Photos of hot tub and portion of patio

Chris Stacey - Zoning Specialist
Department of Permitting & Inspections
City of Portland
389 Congress St.
Portland, ME 04101
(207) 874-8695
cstacey@portlandmaine.gov

Highest Annual Tide and Setback Sketch

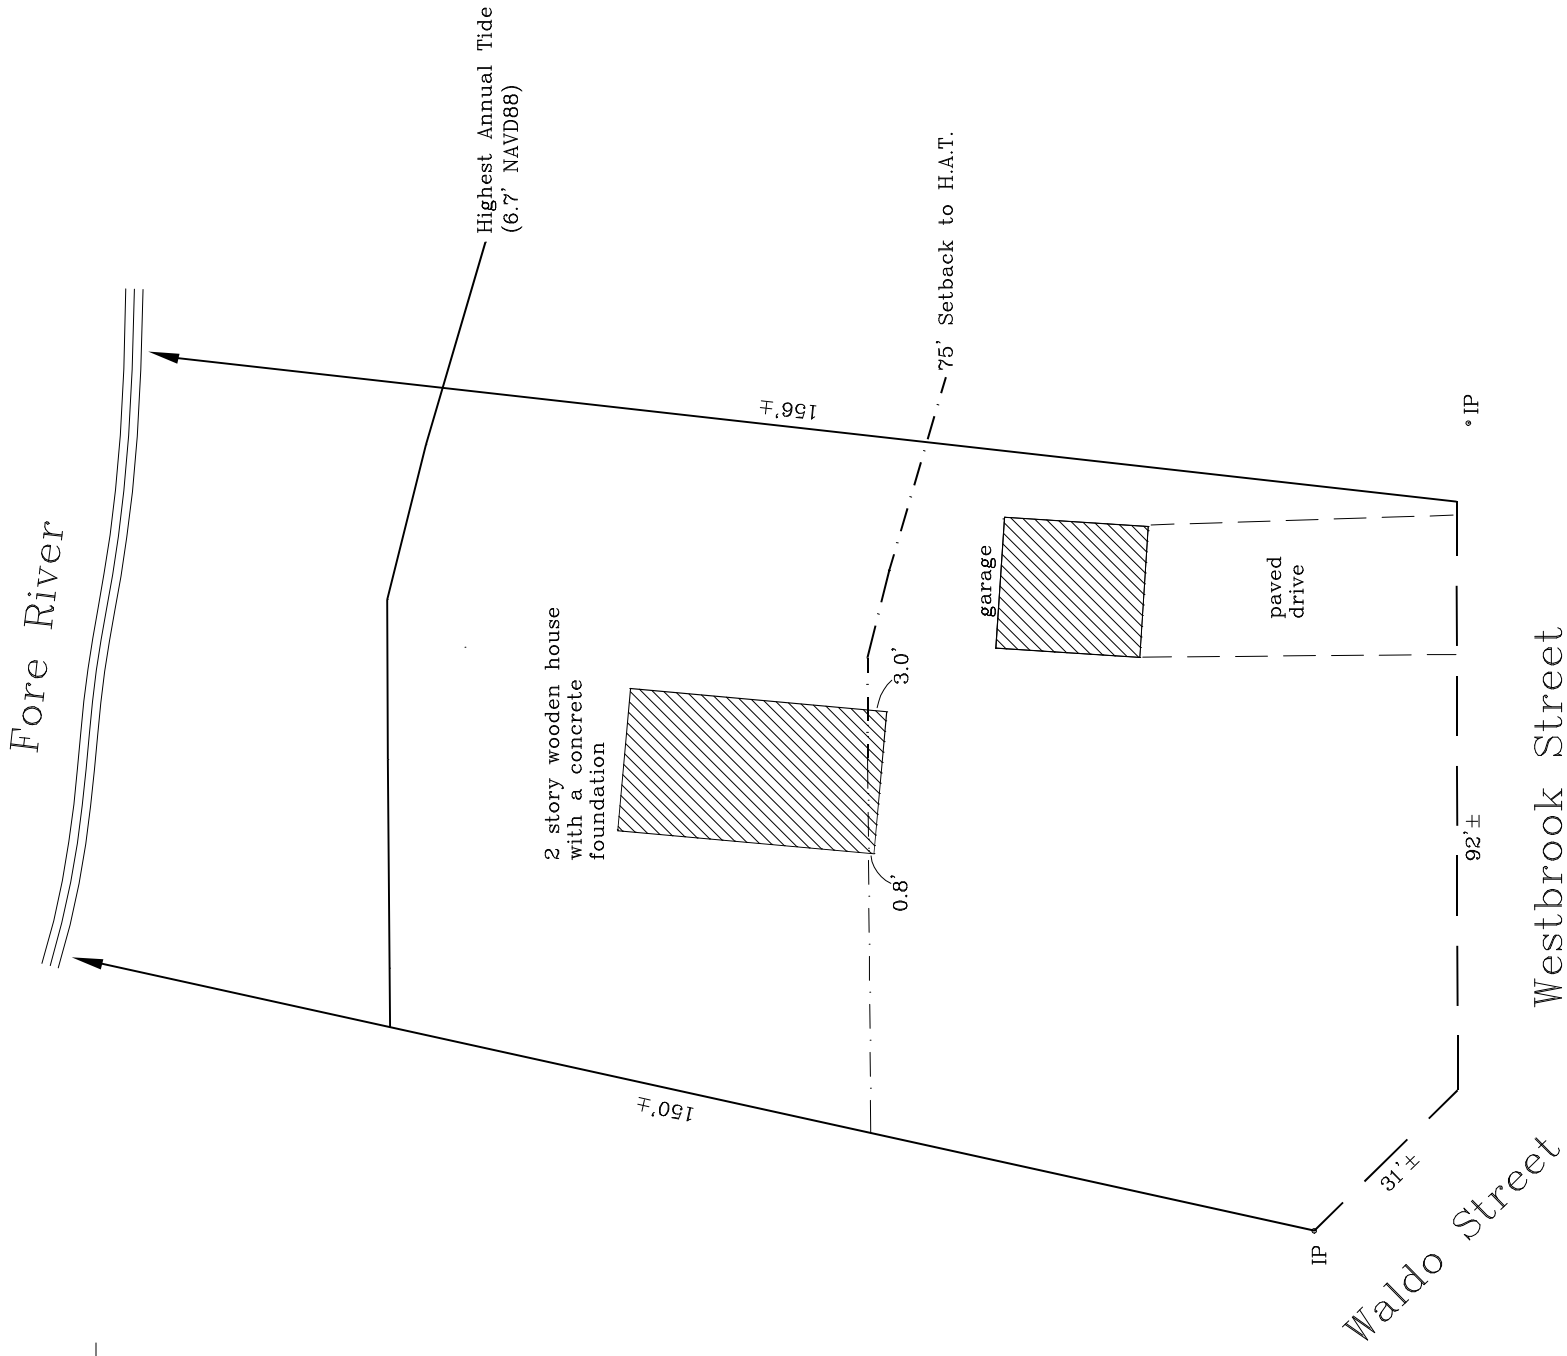
I just tried returning Thimi's call but he was not available. I think we can move forward if you are withdrawing the patio from the proposal. We would normally ask for an updated plan but in the interests of time I can make some annotations on the plan for you. Are you OK with just loaming and seeding the area that the patio was going to be in?

Sorry but these are not adequate to show the existence of an 18' by 24' patio. I do see the hot tub next to the lower deck, although I do not find any city permits for this, either, so I do not think we would consider it a legally existing installation. And it is in a different location than the proposed new patio anyway. I would recommend you revise your plan to remove the patio unless you can provide better photos showing a patio of that size. You could find a location beyond the 75' setback for the patio if you wish.

Dear Chris,
Yes I agree. I will Liam and seed the area around the walkway to the basement. Thanks to you and Phil for moving quickly today.
Betsey

If so, I withdraw the request for a patio.
